# **KIRKLEES METROPOLITAN COUNCIL INVESTMENT & REGENERATION SERVICE**

### **DELEGATED DECISION TO DETERMINE PLANNING APPLICATIONS**

| Reference No:         | <b>2026/62/91324/W</b>                                                        |
| Description:          | Erection of two storey side and single storey rear extensions and alterations |

south elevation

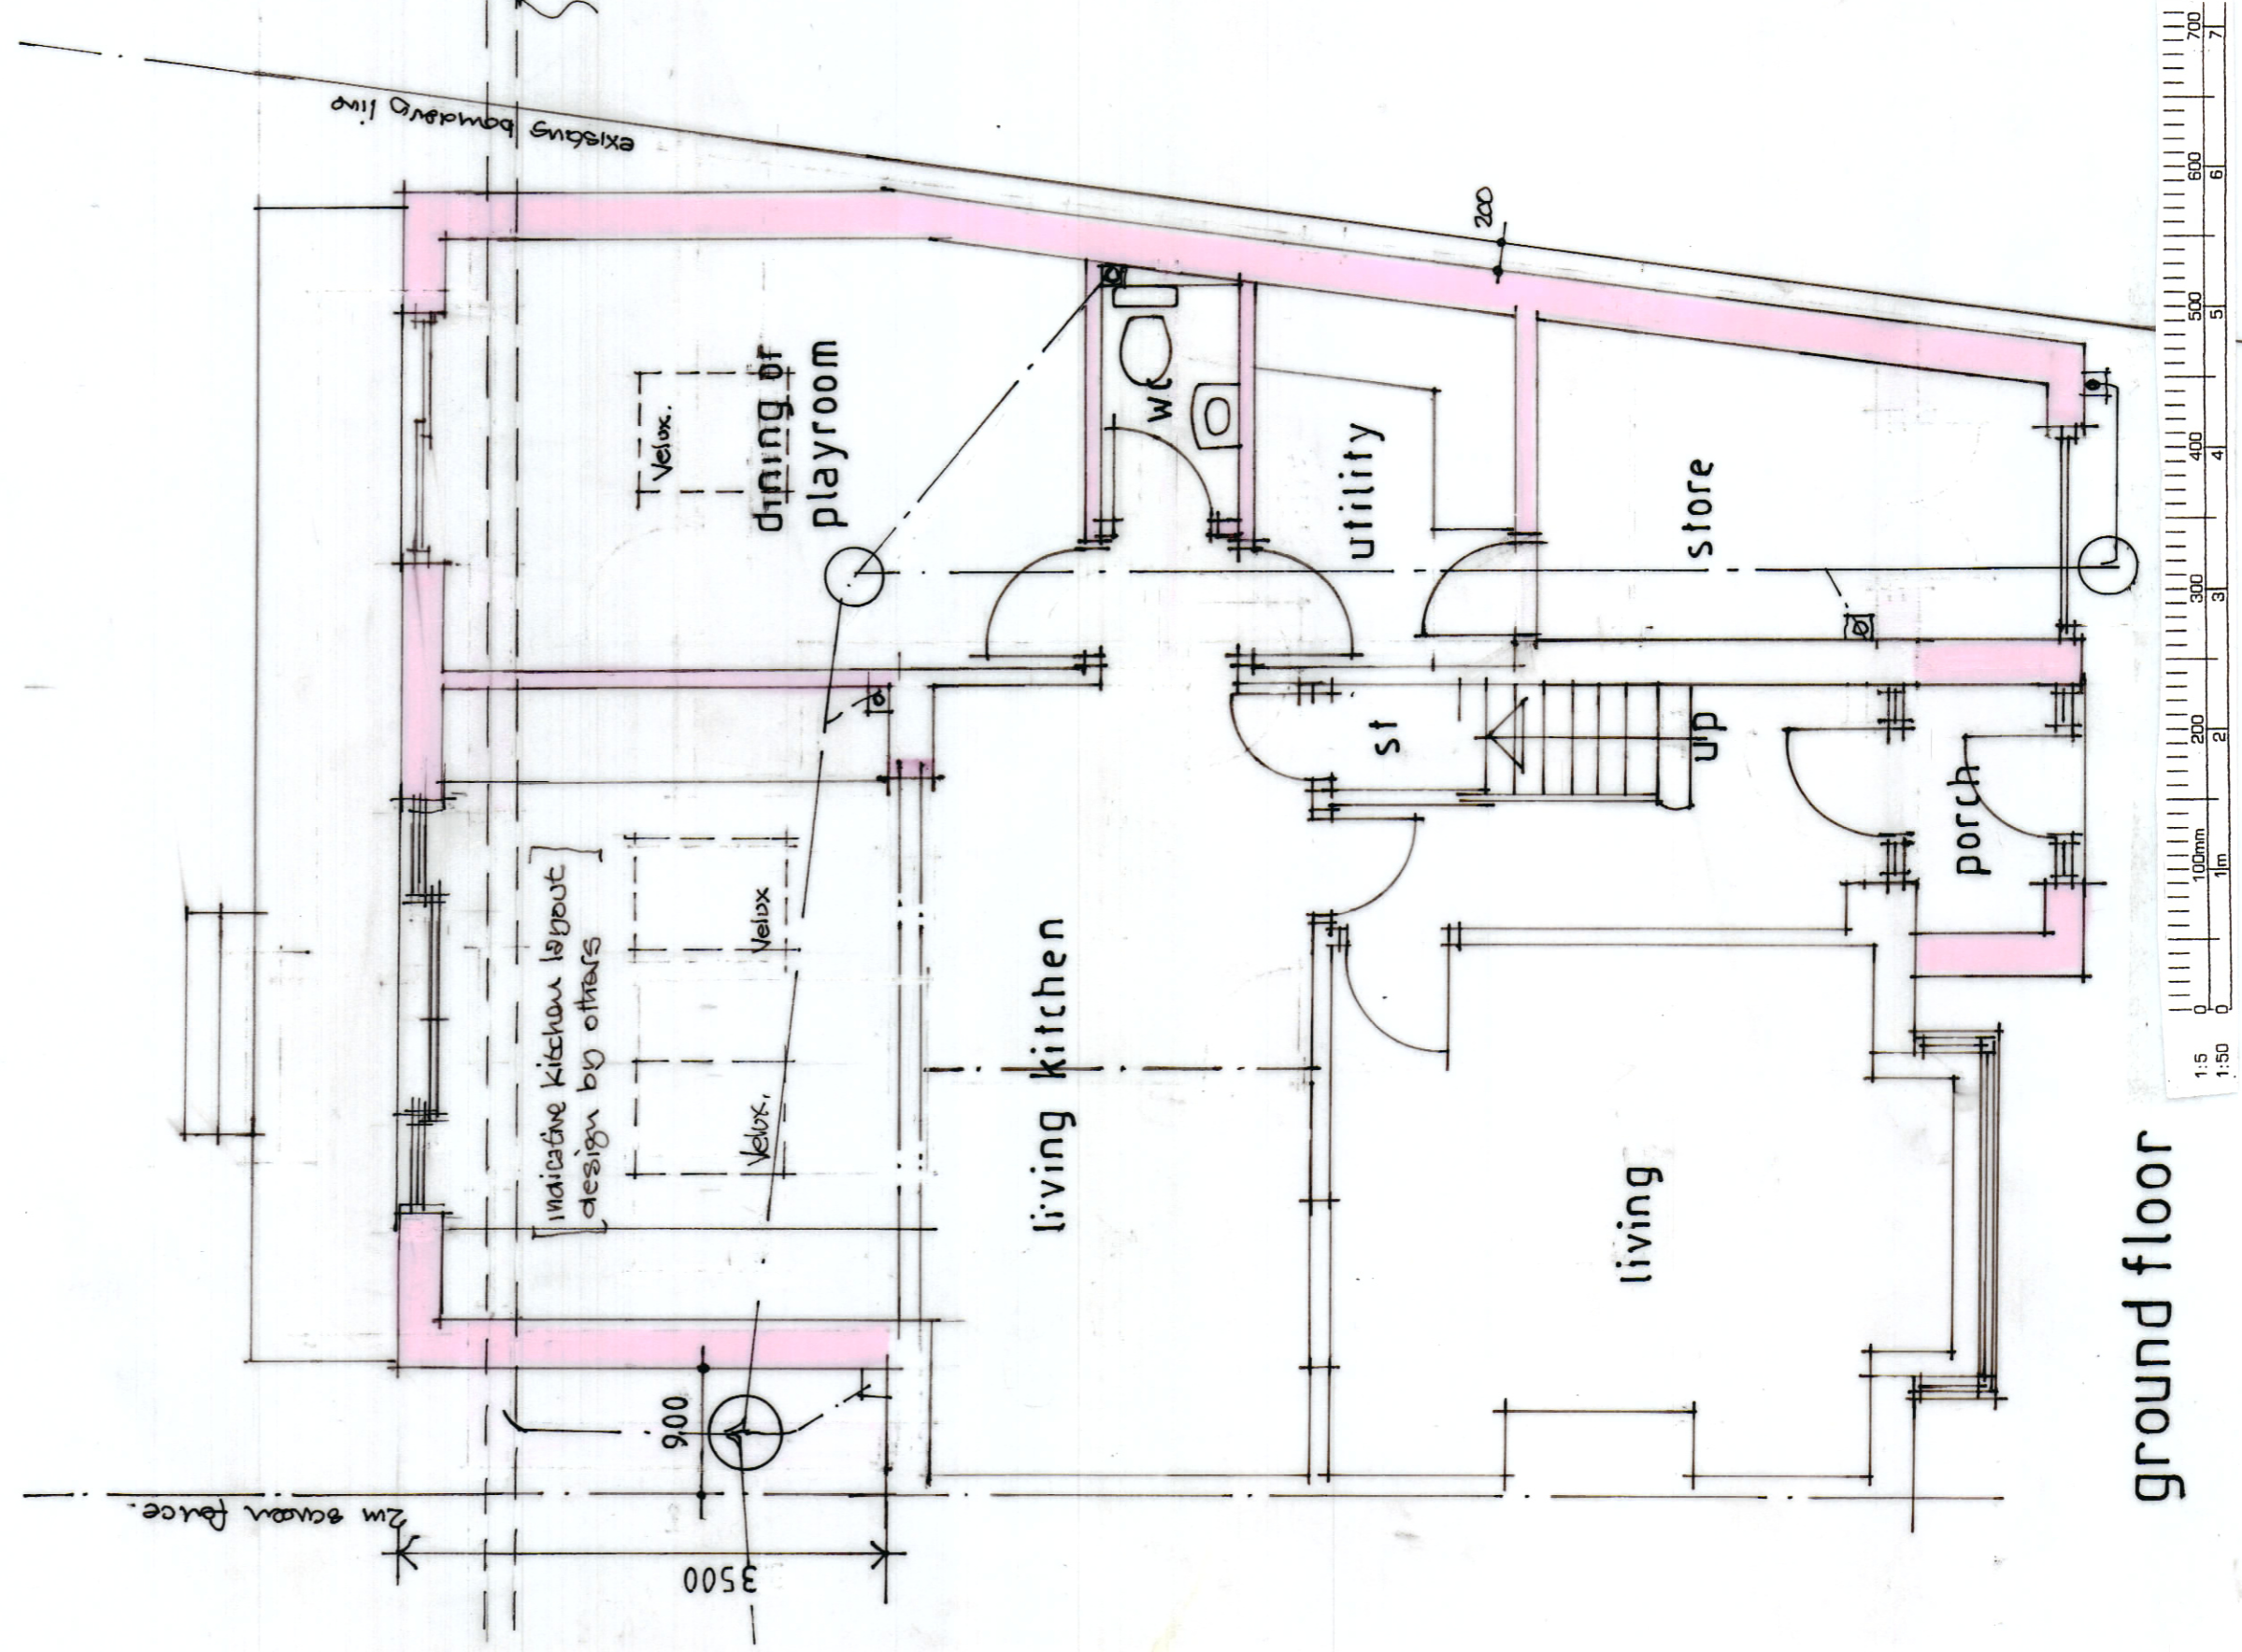
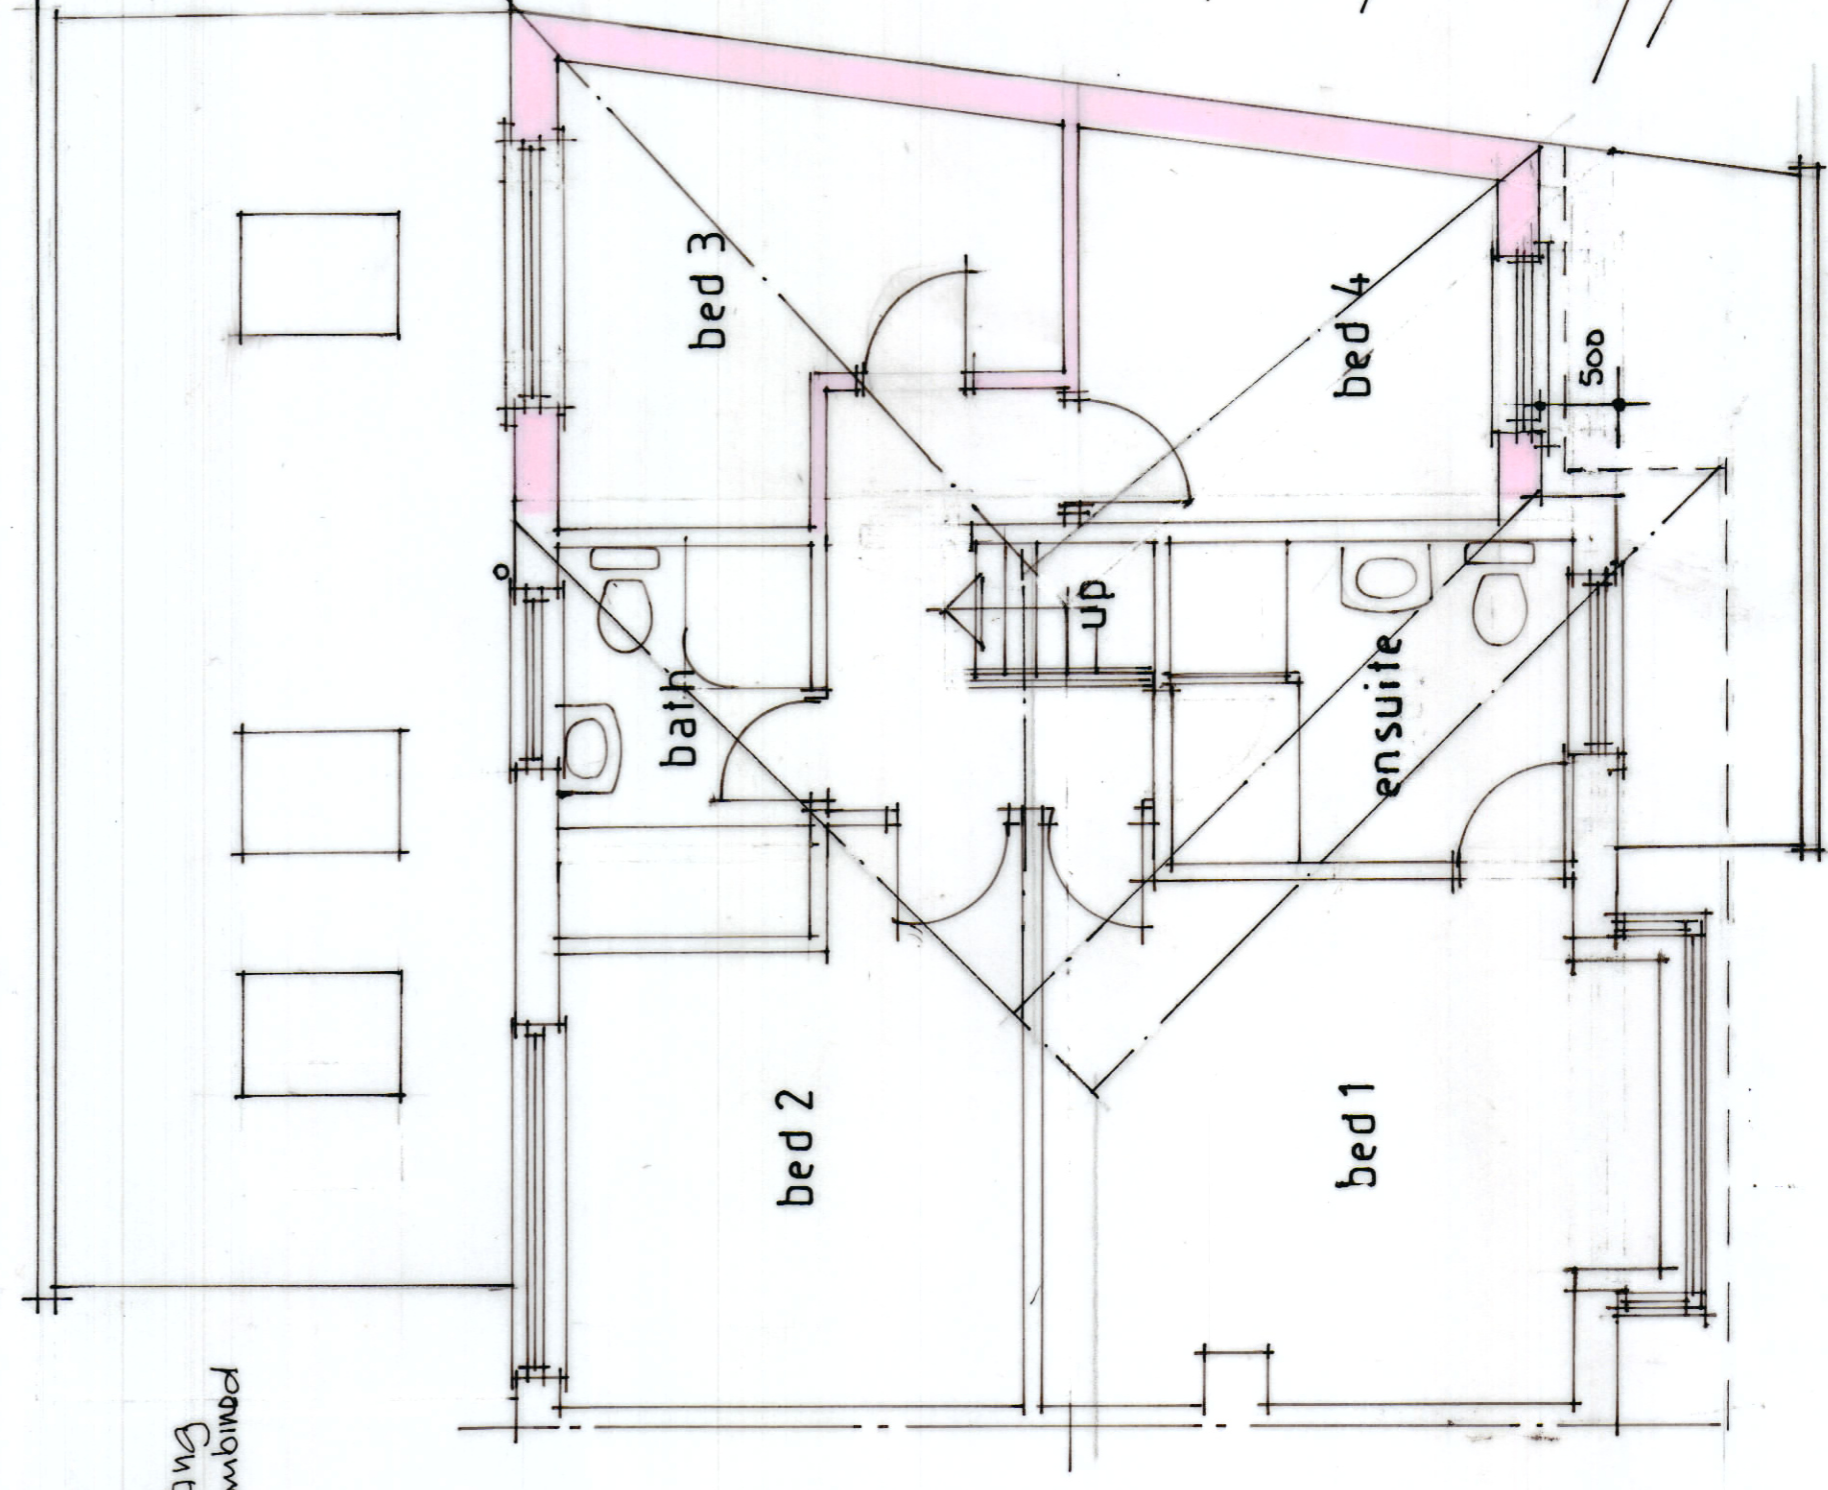
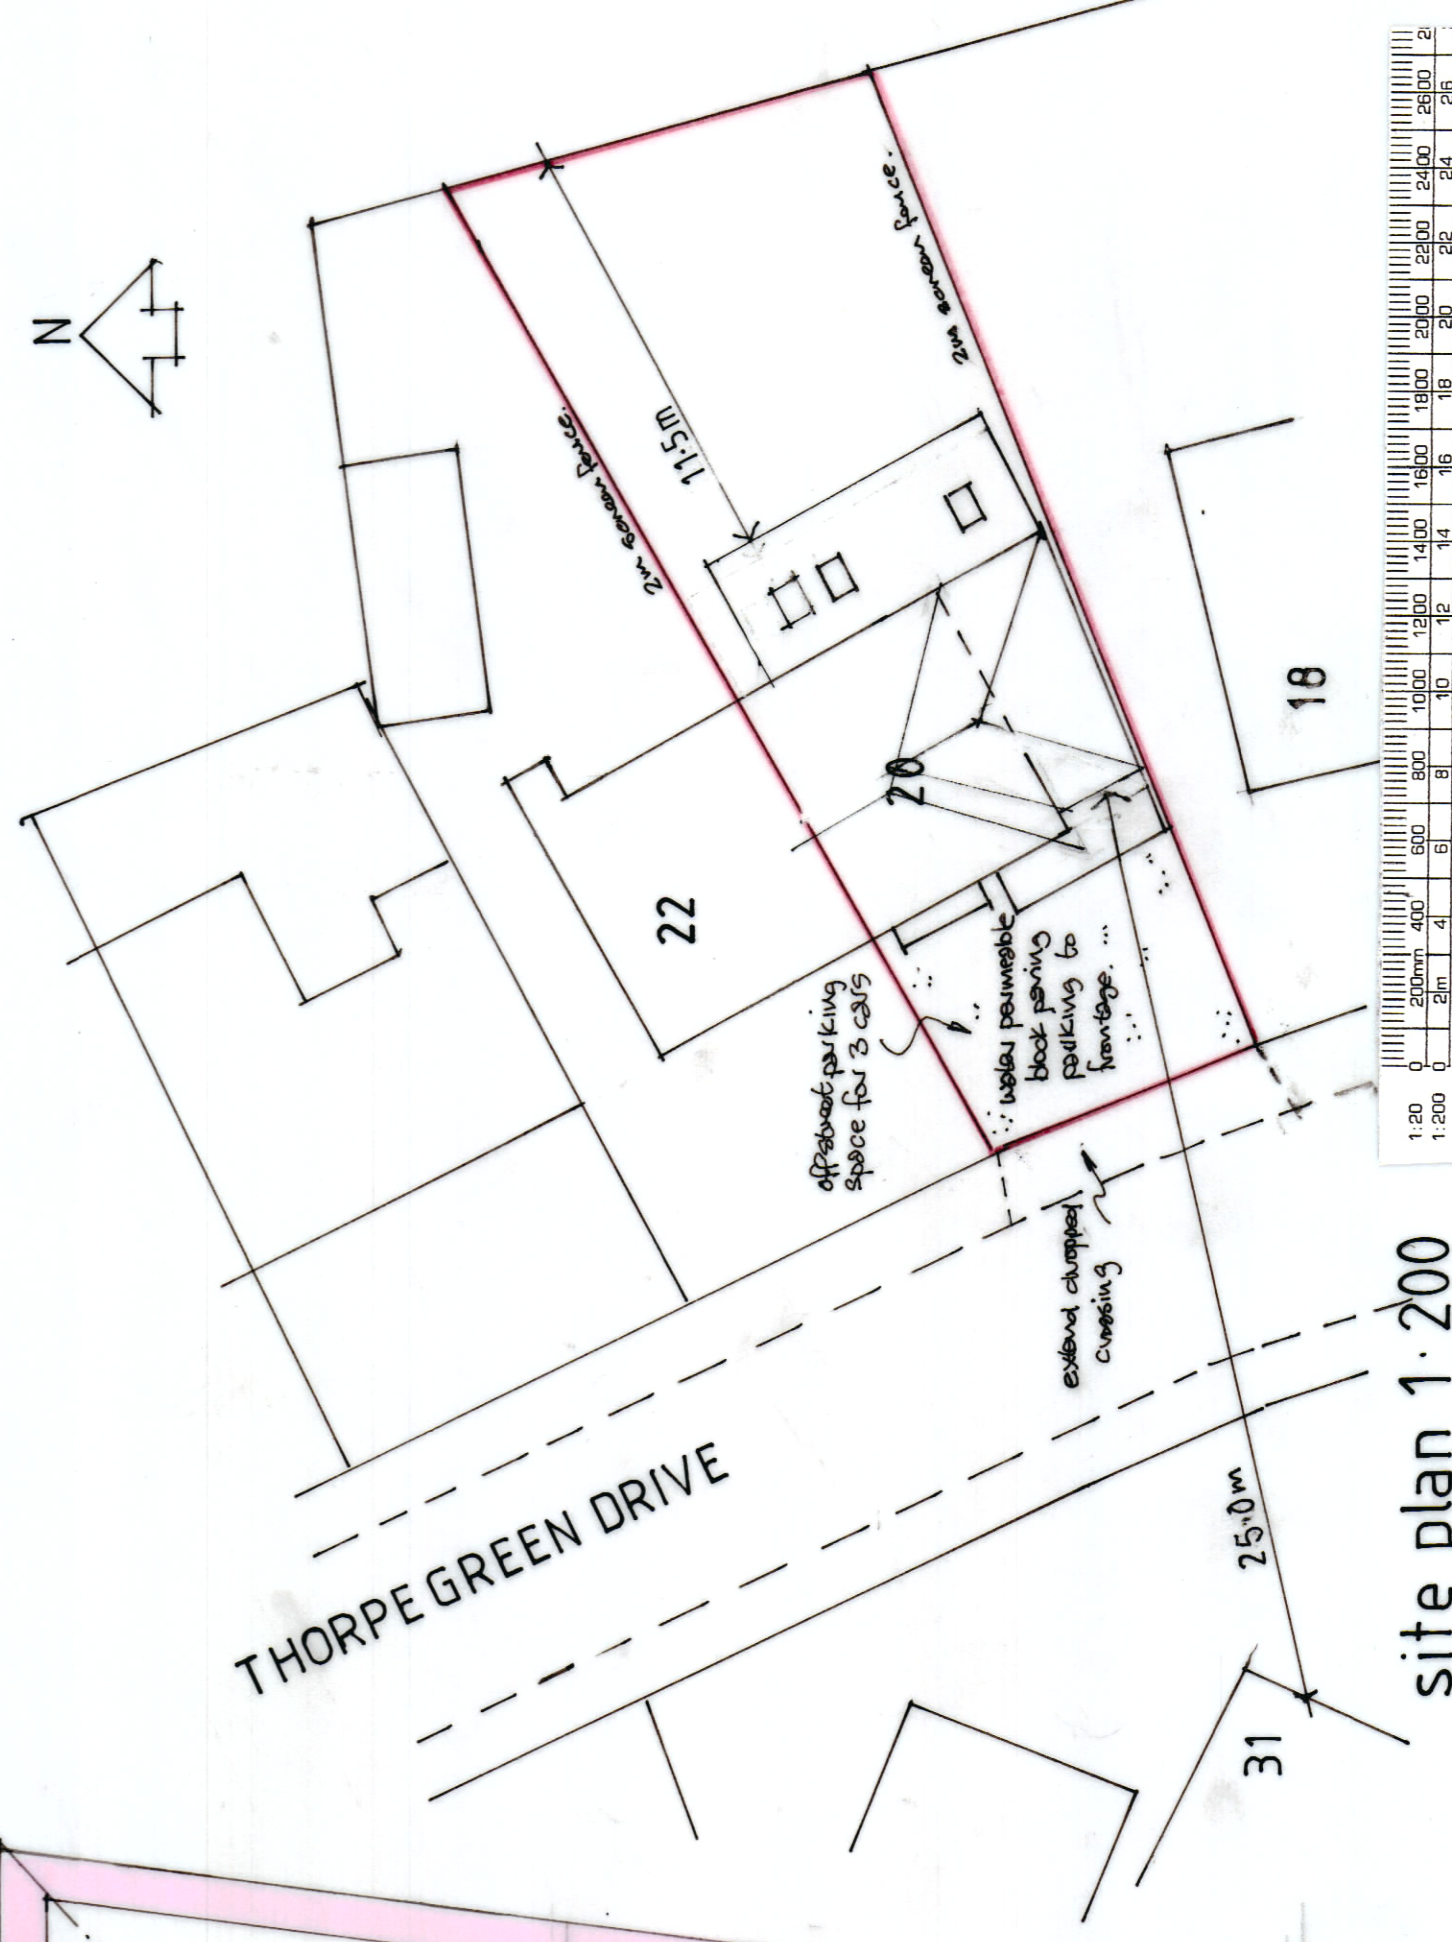
The proposed side extension would occupy the majority of the existing gap between the host dwelling and the side boundary, leaving a separation distance of approximately 0.2m. It is acknowledged that the spacing between dwellings is a defining characteristic of this section of Thorpe Green Drive, contributing to the open and spacious appearance of the street scene. Consequently, the proposal would result in the loss of much of the existing gap to the side of the property and would inevitably reduce this sense of openness.

The extension would be constructed with a hipped roof set below the ridge line of the existing dwelling, which would reduce its overall bulk and ensure it remains visually subordinate to the host property. In addition, amended plans have secured a first-floor set back of approximately 500mm from the front elevation, further creating a subordinate appearance of the extension in accordance with the Council's Extensions SPD.

The proposed two-storey side extension would be positioned adjacent to the side driveway of No. 18. Due to its two storey scale and massing, the extension would inevitably result in some degree of overbearing impact on this side driveway and windows of No.18. During the site visit, it was observed that the development would be situated approximately 3m from the ground-floor side entrance door and a first-floor side window serving No. 18. However, the first-floor window is relatively small in scale and is considered likely to serve a landing or other non-habitable space, rather than a primary habitable room.

The submitted plans confirm that no windows are proposed within the side elevations of the extension. Consequently, the development would not give rise to any unacceptable overlooking or loss of privacy for the occupants of No. 18.

Kirklees Council Highways Development Management has been informally consulted during the assessment of the application. In light of the increase in the number of bedrooms and the associated parking demand, officers have reviewed the proposed parking arrangements. The entire front curtilage would be hard surfaced, providing an area of approximately 7.5m in width by 5.5m in depth. Officers consider this to provide sufficient space to accommodate three off-street parking spaces, in accordance with the guidance set out in the SPD.
